KITTITAS VALLEY FIRE & RESCUE

KVFR Prevention Short Plat Comments

Project: Carr
Permit#: SP-24-00002
Date: 03/21/2024

CARR SHORT PLAT  
 PART OF SECTION 35, T. 17 N., R. 19 E., W.M.  
 KITTITAS COUNTY, WASHINGTON

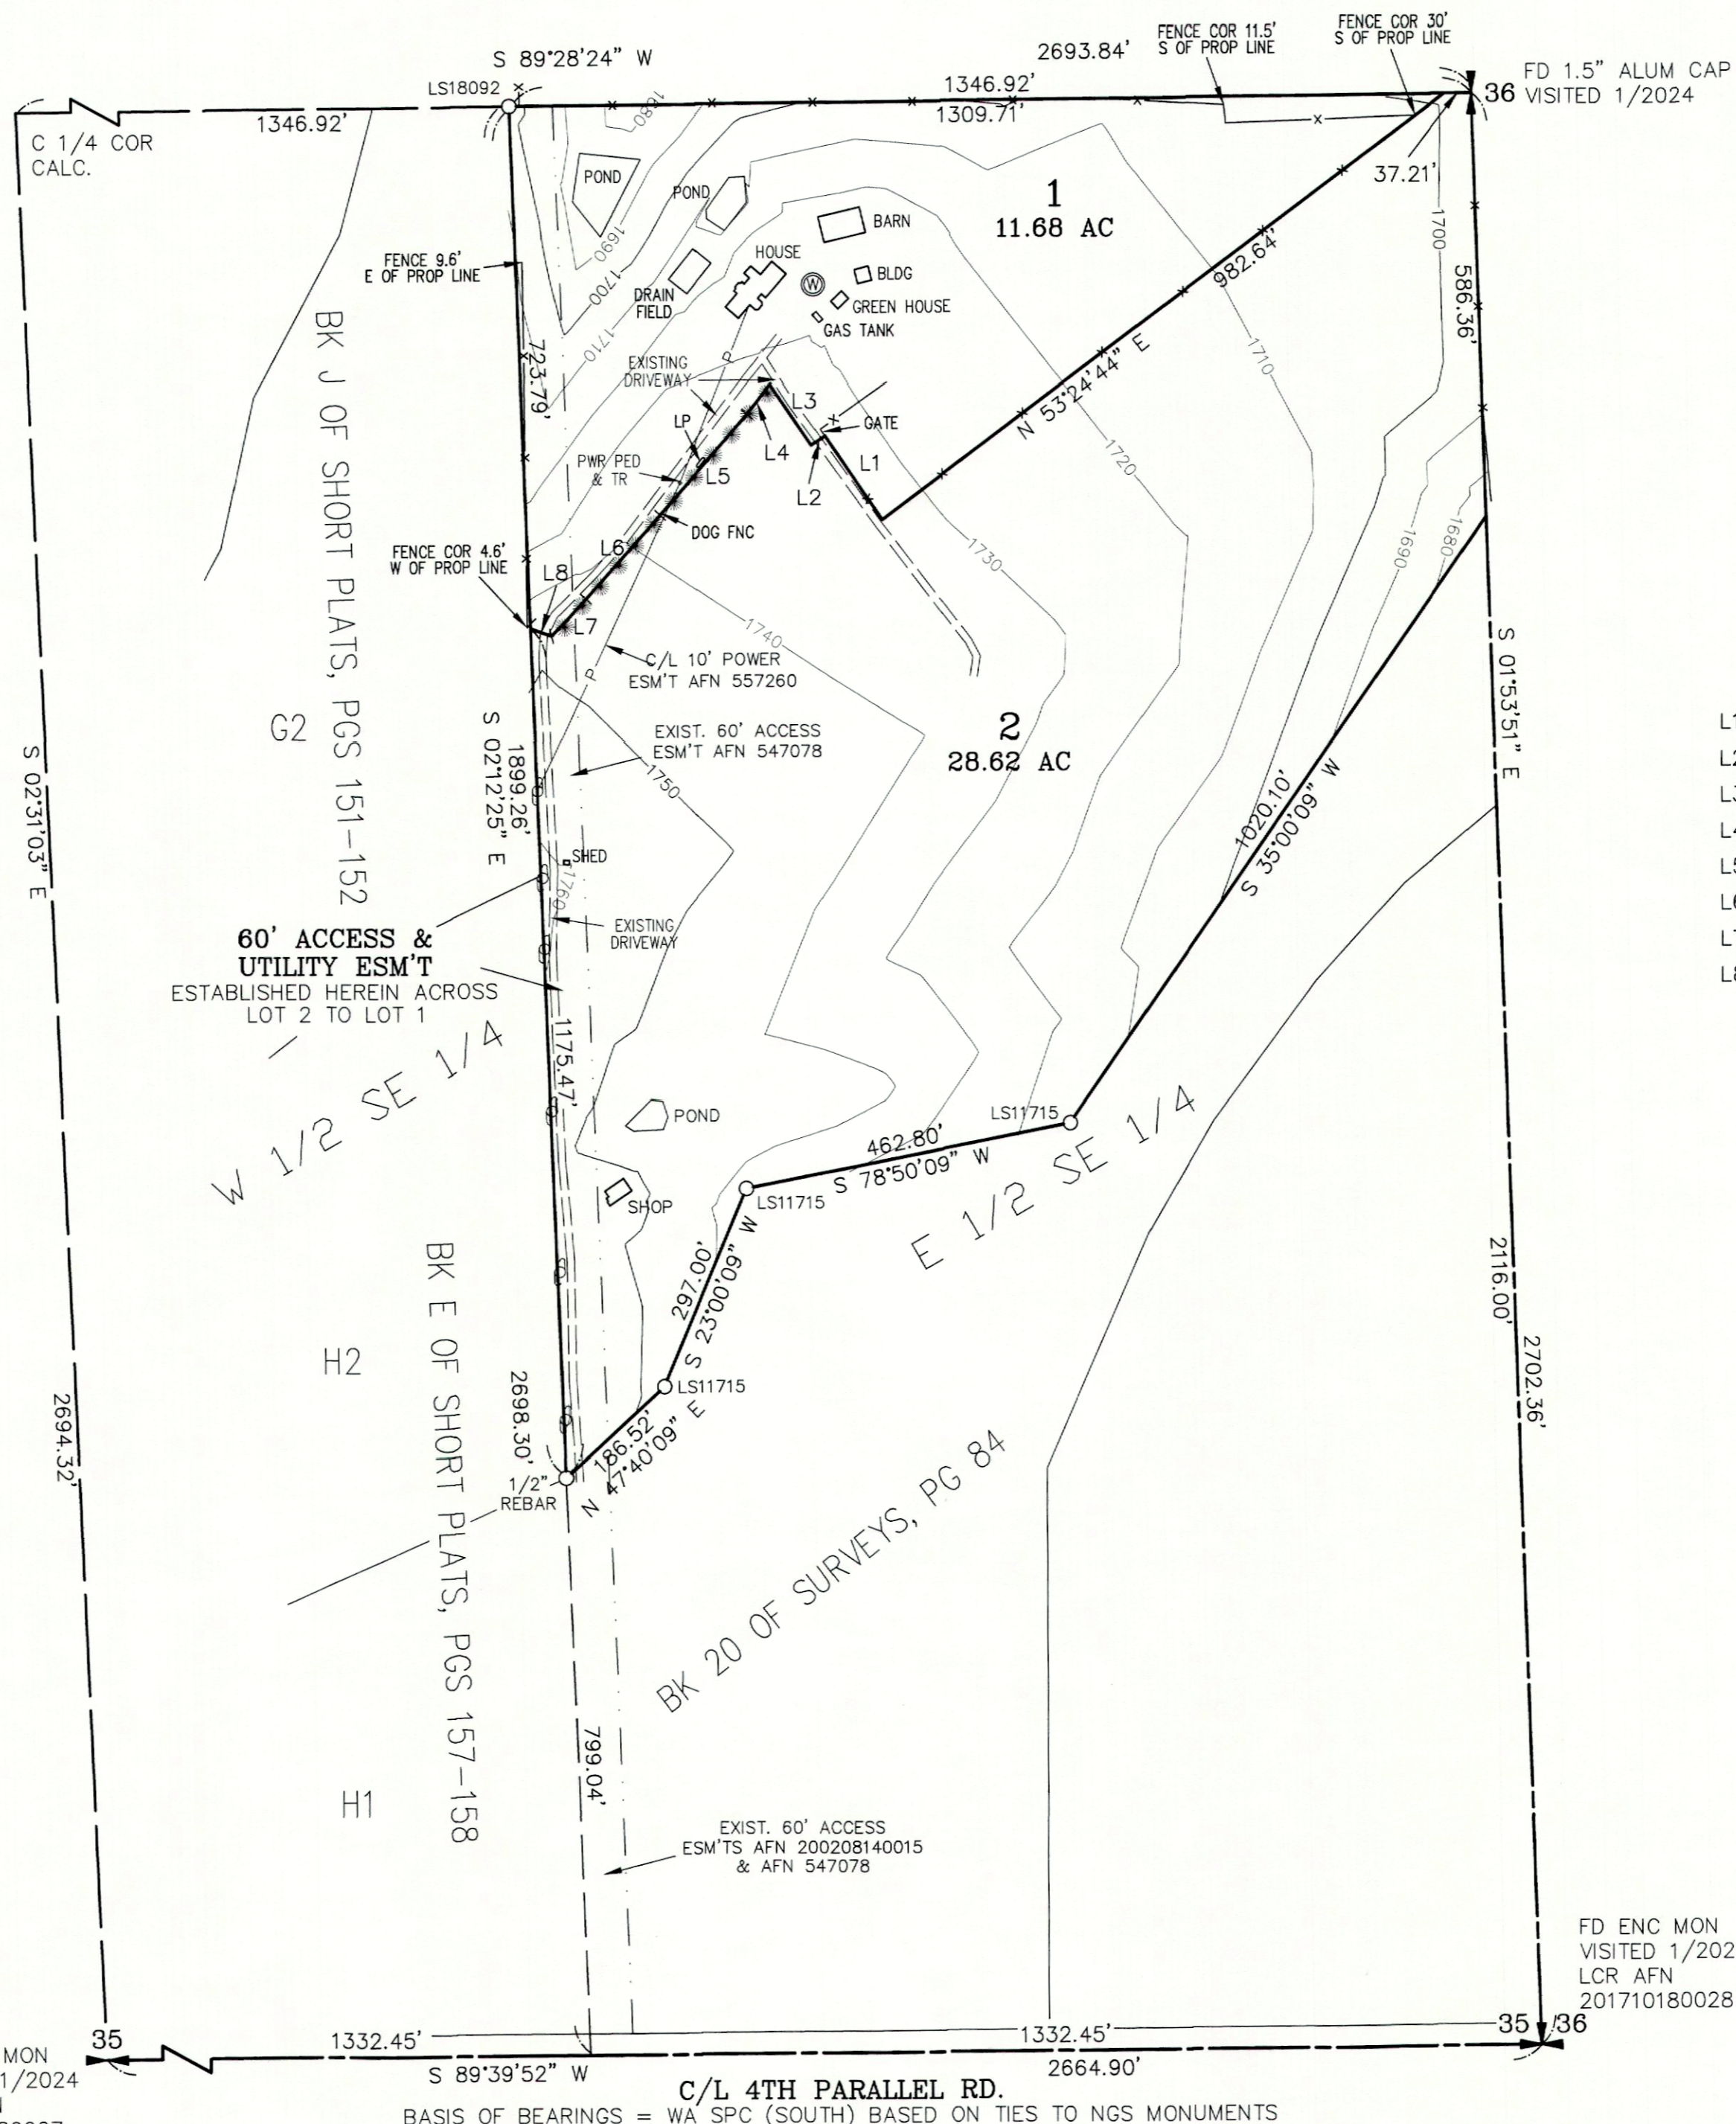
- Fire apparatus access roads exceeding 150' shall be provided with a temporary or permanent turnaround meeting the requirement 2021 IFC Appendix D.
- Fire apparatus access roads shall not exceed 10% in grade. This is especially critical in our valley's climate.
- The IFC Appendix D requires the road be a minimum of 20' wide and capable of supporting an imposed load of at least 75,000 lbs.
- Our standard turning radius is a minimum of 23' inside and 45' outside.
